Conservation Area Advisory Committee

✓
AB/92/12/L

Application for Listed
Building Consent for first &
second floor extension & rear
rooflights (amendments to
AB/60/11/L)33 Mount Pleasant
Arundel

Proposed Roof Plan

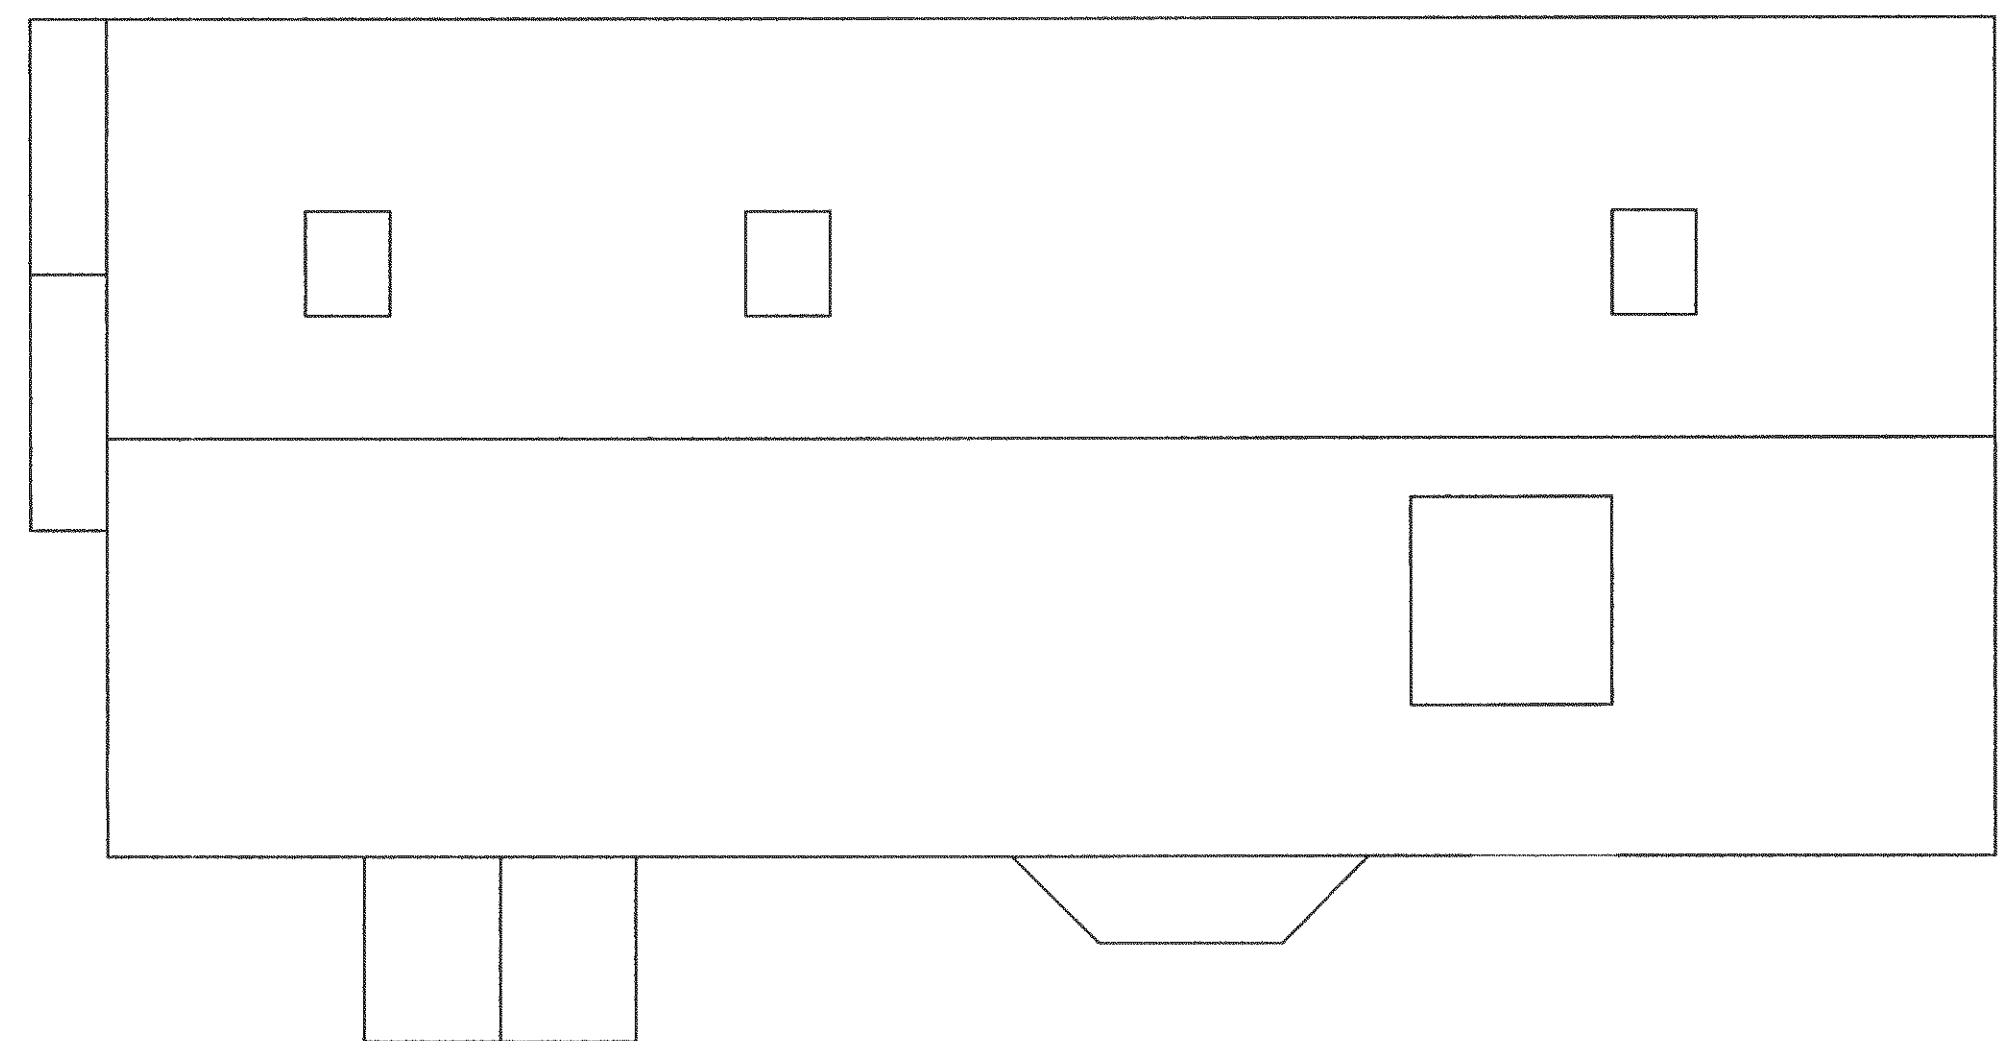
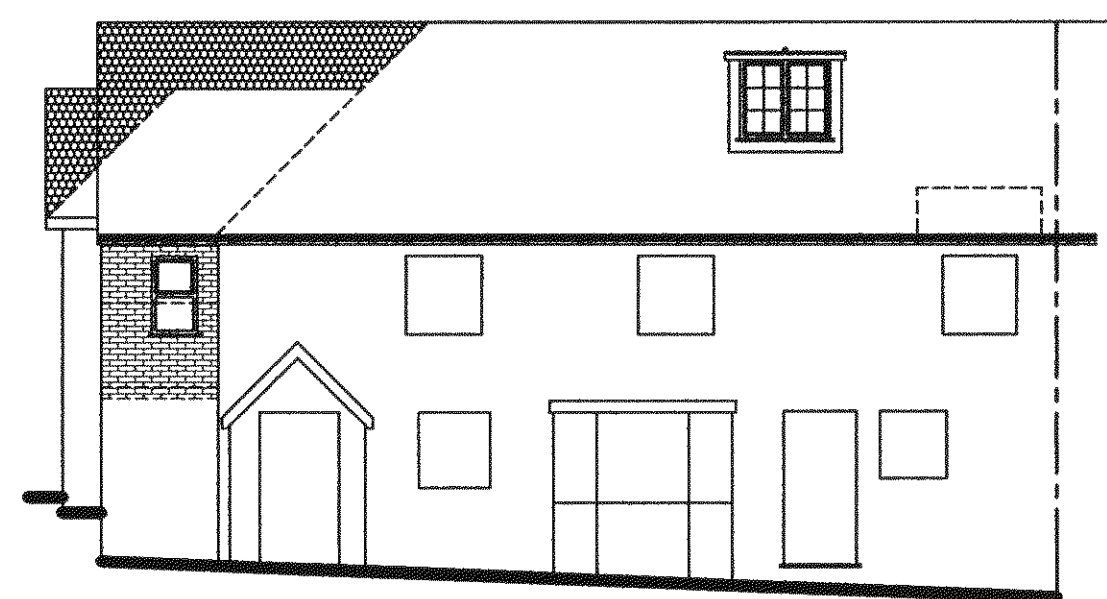
Comment
Query the
number of
dormers

Quality of materials & finishes
relating to the
roof lights to the
building is crucial
